Planning Department Transportation Development Services

Re: GAHH Relocation & Tenant Improvements, 4900 Menaul Blvd. NE

Certificate of Occupancy – Transportation Development

Architect's Stamp dated 08-19-14 (H17-D110)

No.	Description	Date
20_1225	CAD DWG FILE: DWL-NM_RESTORE	
	DRAWN BY: B. RAEL	
	CHECKED BY: R. BURTON	
	SHEET TITLE: TRAFFIC CIRCULATION PLAN

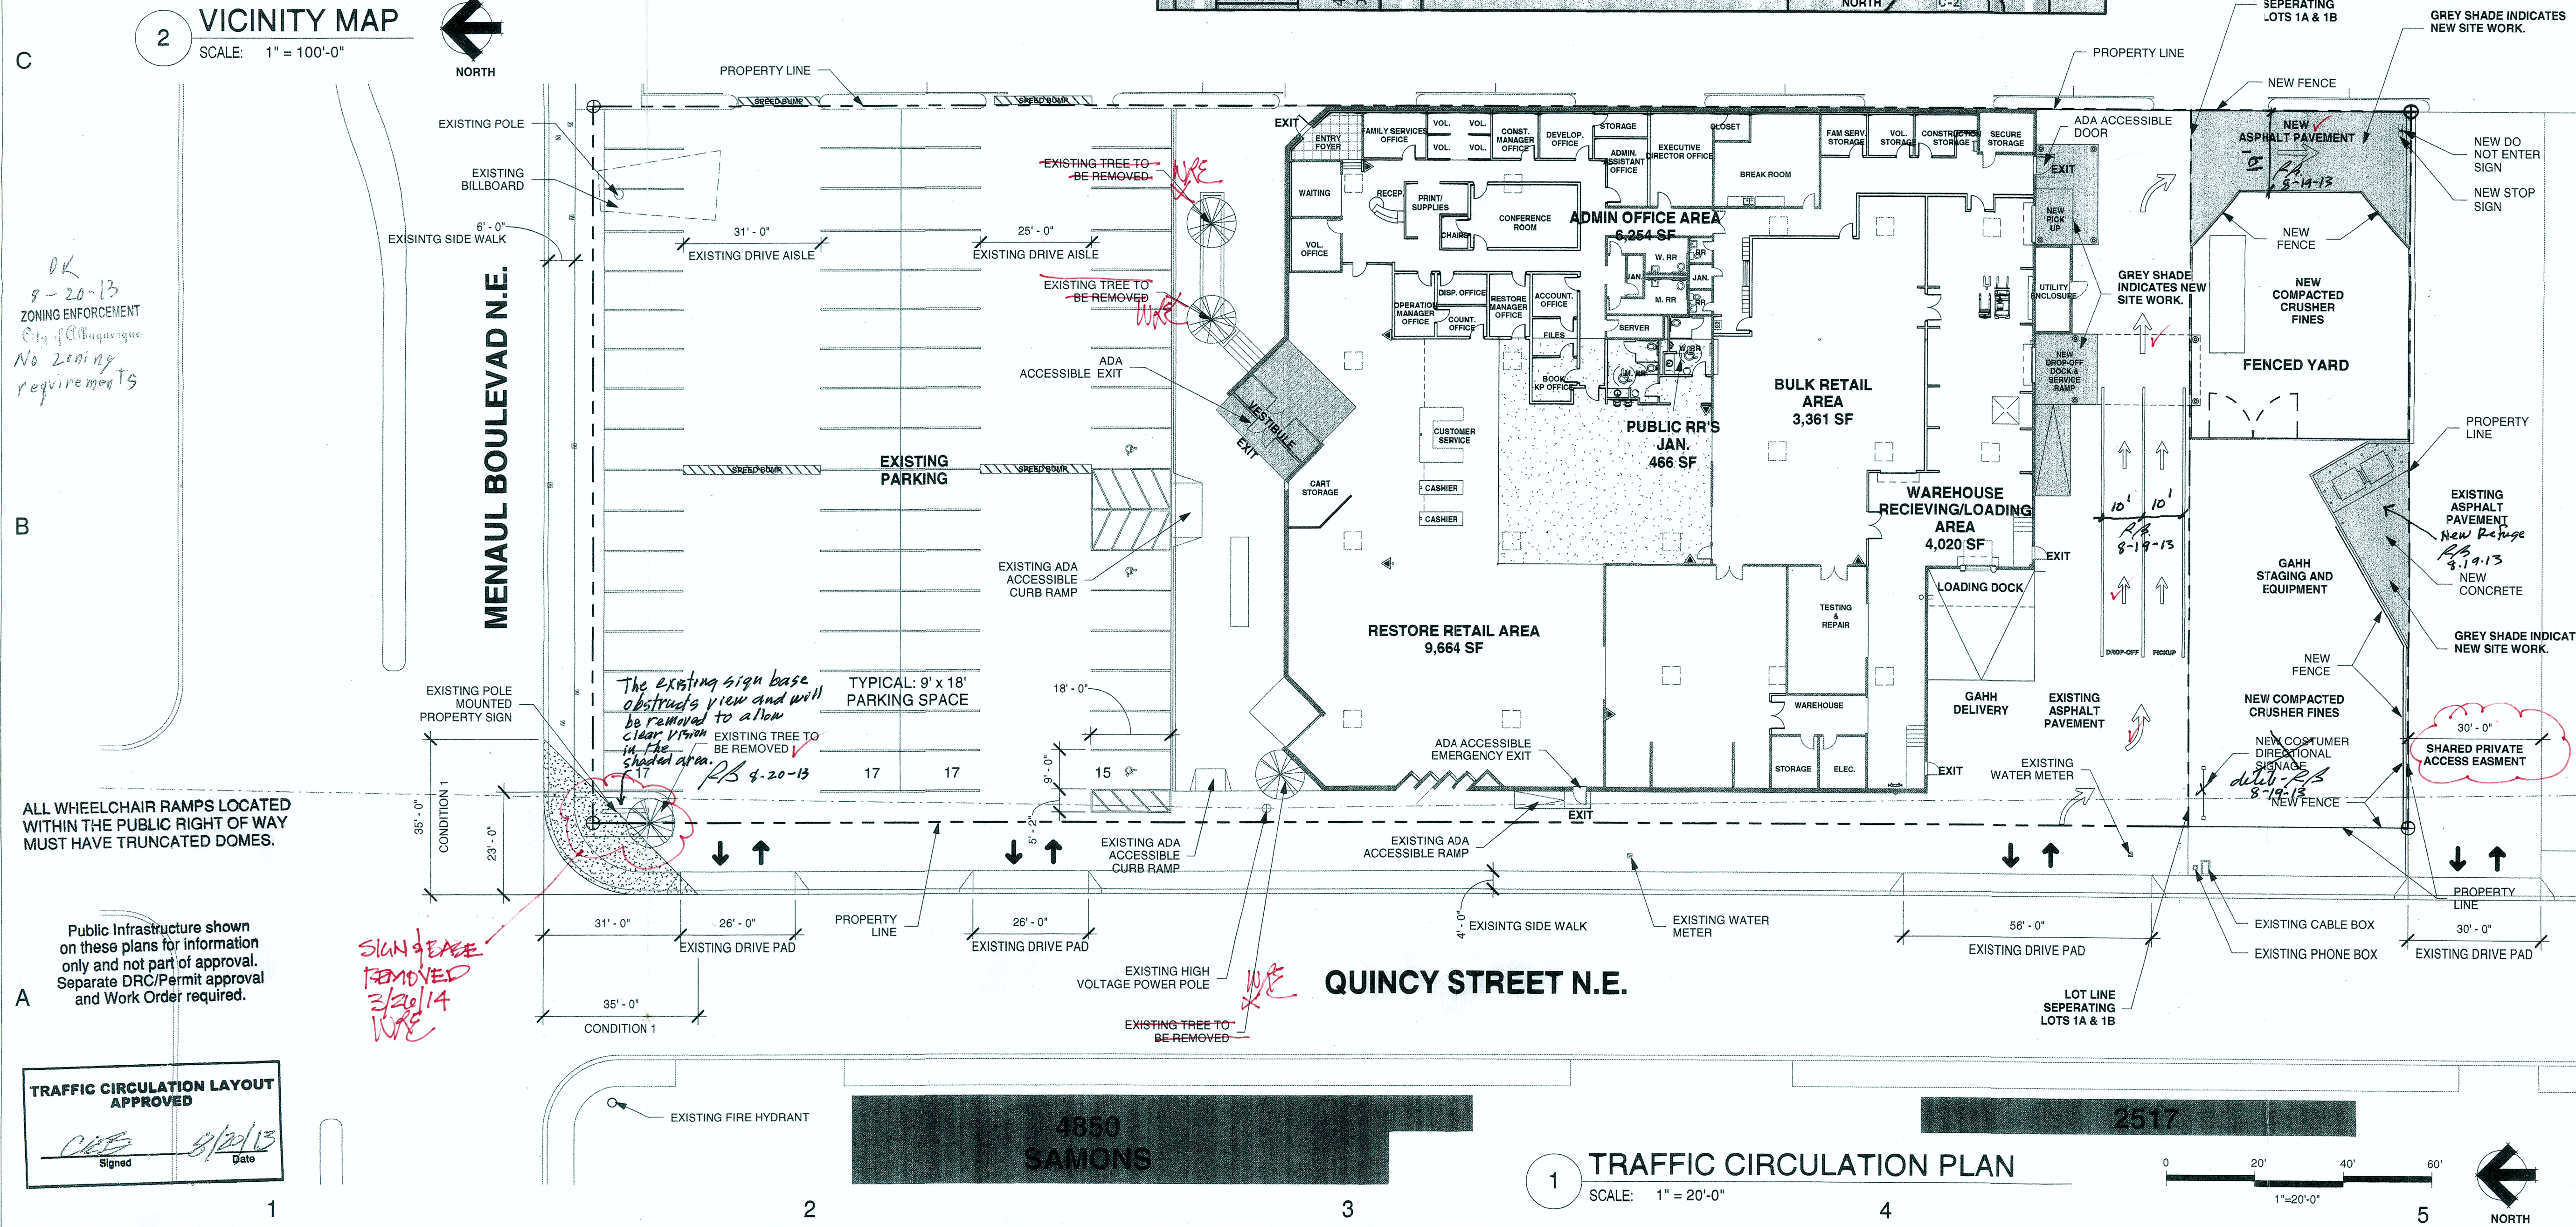
The existing sign located at the corner of Menaul and Quincy, including the pedestal, must be removed.

Signing and striping of the drop off area south of the building must be completed. At this time, compacted crusher fines and/or base course may be used to tie into the existing 30-foot wide shared access easement, with the understanding that asphalt pavement will be placed at a later date.

Mr. Burton your submittal for the correct lot lines location setback were shown to be 7 (seven) feet from the face of curb. This measurement was used to the determine

The appropriate property line and it appears that the on-site light poles (3) and the existing monument sign still encroaches into COA ROW. Please provide address this concern.

- The existing sign foundation is an obstruction for stopping sight distance and will need to be removed as stated on the approved TCL Site Plan dated 8/20/13.
- The existing parking bumpers, vehicle overhang, and street lights appear to be encroaching and/or located within COA ROW. These encroachments will need to be addressed.

- 1. Please show a vicinity map.
- 2. Please provide the legal description of the site.
- 3. Please provide a line-type legend.
- 4. Please label, dimension and detail all line-types, distinguishing between existing and proposed (include any refuse area, fences, walls, gates, ramps, railings, speed humps, landscaping, signs, property lines, pedestrian paths, curbing, fire hydrants, light posts, support posts, overhang structures).

- 5. The site appears to be composed of two lots (1A & 1B4) with the shared private access easement within lot 1B4. Please clarify lot lines.
- 6. Please include a copy of your shared private access easement with the adjacent property owner(s). There are several shared access points from the site, are there shared access agreements for each location?

- 7. Will site be replatted to consolidate lot lines?
- 8. Please list the width and length for all parking spaces.
- 9. List the number of parking spaces required by the zoning code as well as the proposed number of parking spaces.

- 10. The handicapped spaces must be a minimum of 8.5 feet in width.
- 11. The handicapped spaces must include an 8-foot wide van access aisle; all other aisles should be 5 feet in width.

- 12. Define width of the existing sidewalk.
- 13. Pedestrian walkways shall be provided from all street sidewalks to the principal customer entrance(s) on the nearest building(s) on a site. The path(s) must be ADA accessible, clearly demarcated, six feet minimum width and not located behind parking stalls.

- 14. Please refer to all applicable city standards.
- 15. Please ensure all ramps are ADA compliant.
- 16. List the width of the existing drivepads.
- 17. List the widths of parking lot drive aisles, drop-off lanes and exit drive.

- 18. One-way orientation requires posted signs and pavement markings to gride vehicles.
- 19. Per Chapter 23, Section 6, Part B.5 of the City of Albuquerque Development Process Manual, any drive on a local roadway that is intersecting with a minor arterial must be located a minimum of 50 feet from the intersection. Please provide the distance the drivepad on Quincy is set back from the intersecting point with Menaul Blvd.

- 20. Show the median break on Menaul Blvd in reference to the site?
- 21. There appears to be existing signage along the Menual Blvd. frontage. Signage must not encroach onto COA right-of-way, including air space, without a Revocable Encroachment Agreement.

- 22. The apparent signage along the Menaul Blvd. frontage must not interfere with the sight distance of the intersection. Please provide a sight distance exhibit (see the *Development Process Manual*, Chapter 23, Part B, Section 5.a).

- 23. Per the Development Process Manual, Chapter 27, Section 7, Part F.II, a scale of 1"=20" is recommended for sites of less than 5 acres.
- 24. A scale must be shown on the plan. Per the Development Process Manual; Chapter 27, Section 2, Part B.1, only the following scales may be used:
 - $\bullet \quad 1" \quad = \quad 50'$
 - 1" = 40'
 - 1" = 20'
 - 1'' = 10'
 - 1" = 100' (for overall layouts only).

THE "VIEW TRIANGLE" ENCROACHING BASE AND SIGNAGE AT THE SE CORNER OF MENUAL BOULEVARD NE AND QUINCY STREET NE HAS BEEN REMOVED. REPLACEMENT SIGNAGE WILL EVENTUALLY-BE-INSTALLED UNDER A SEPARATE PERMIT. A HABITAT-FOR HUMANITY ACCESS LICENSE AGREEMENT HAS BEEN ENTERED INTO WITH THE CITY OF ALBUQUERQUE FOR ACCESS TO EGRESS FROM HABITAT PROPERTY ACROSS CITY OF ALBUQUERQUE PROPERTY TO THE PUBLIC RIGHT-OF-WAY.

NO DEFICIENCIES AND/OR REQUIRED CORRECTIONS WERE NOTED.
